From: Laura Gibbons
Sent: 03 October 2018 13:18
To: Planning.Responses
Cc: David Easton
Subject: RE: Planning Consultation on F/16/18/DOC

Engineers Comments Regarding Surface Water Drainage

F/16/18/DOC

Land South Of Burndell Road Yapton BN18 0HR

Soakaway Test No.	TP1 SA1
Contract:	Burndell Road, Yapton BN18 0HR
Contract No.	15276

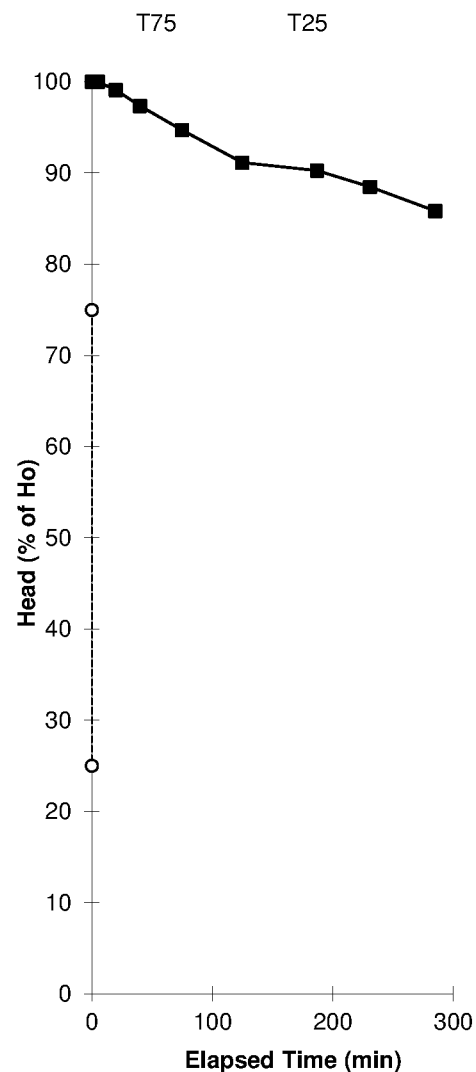
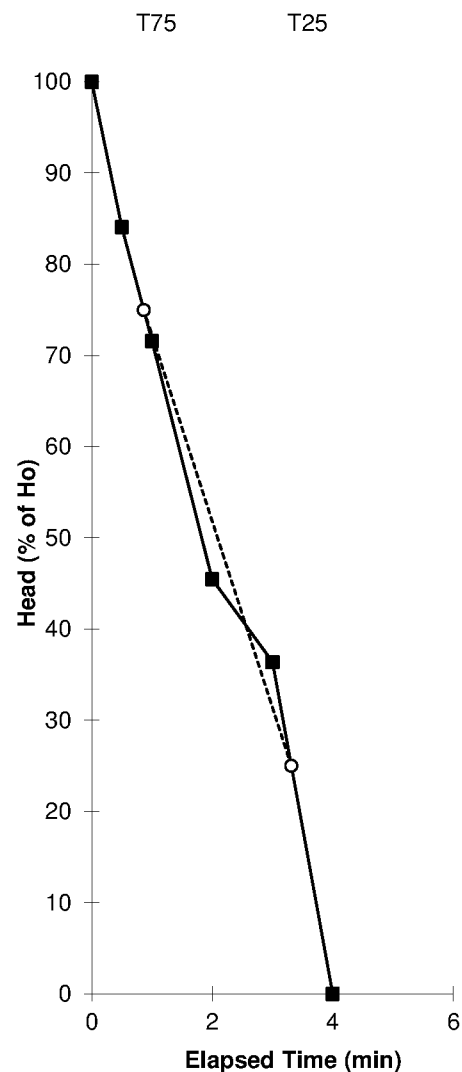
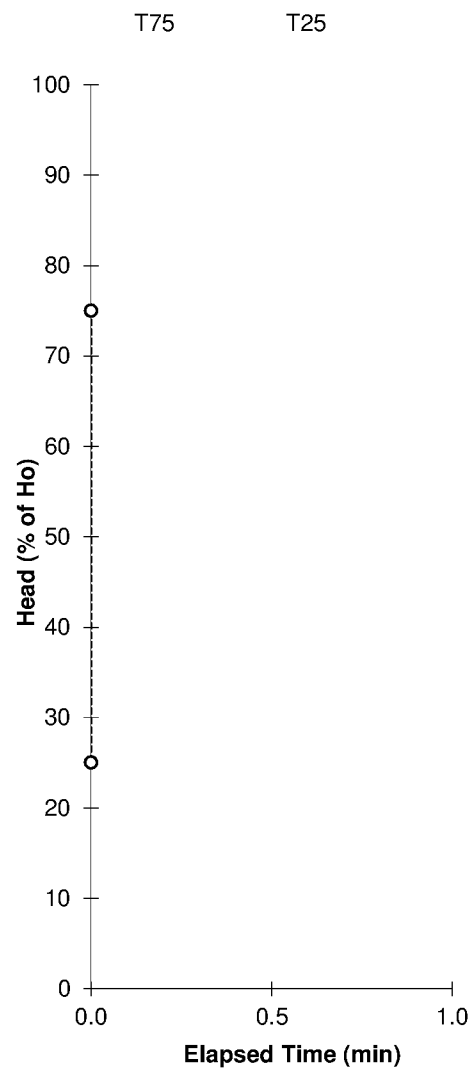
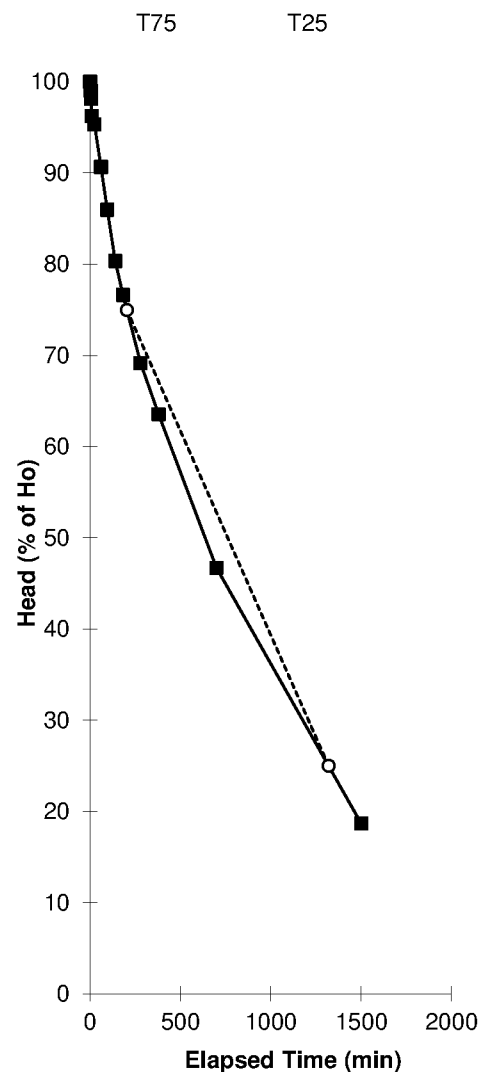
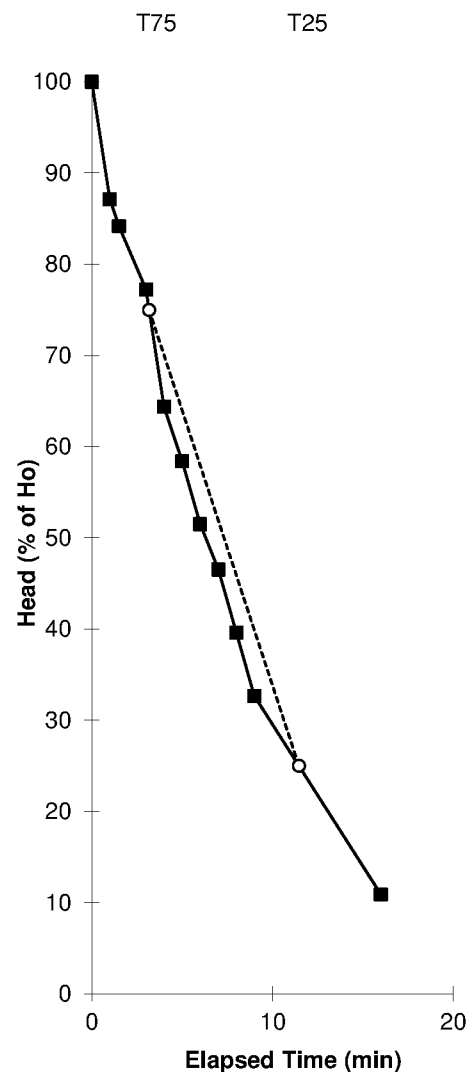
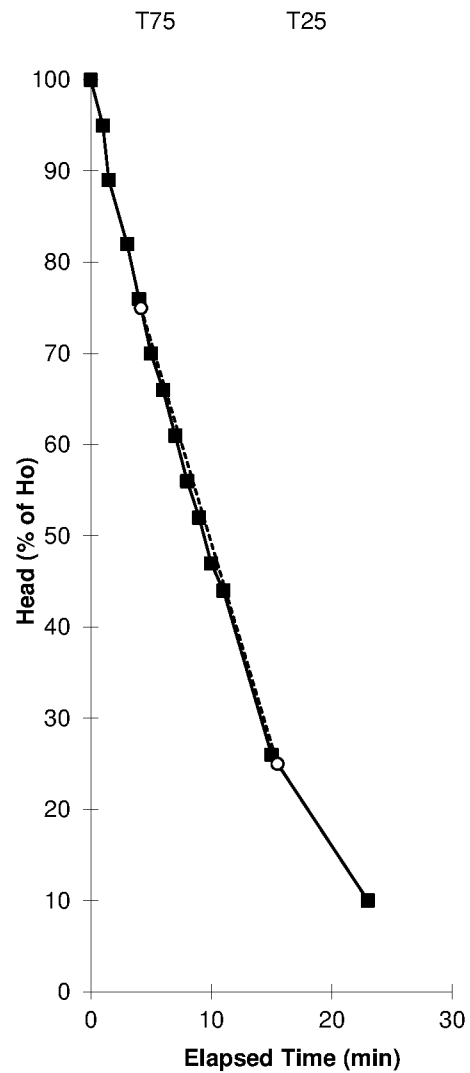
No winter infiltration test results have been supplied with this application. Please supply these. I note that infiltration is referred to as being highly vulnerable, this is not sufficient detail, please provide full test results and locations.

The groundwater monitoring results are also not high enough to rule out infiltration. We do not require 1m clearance between groundwater and the base of infiltration structures.
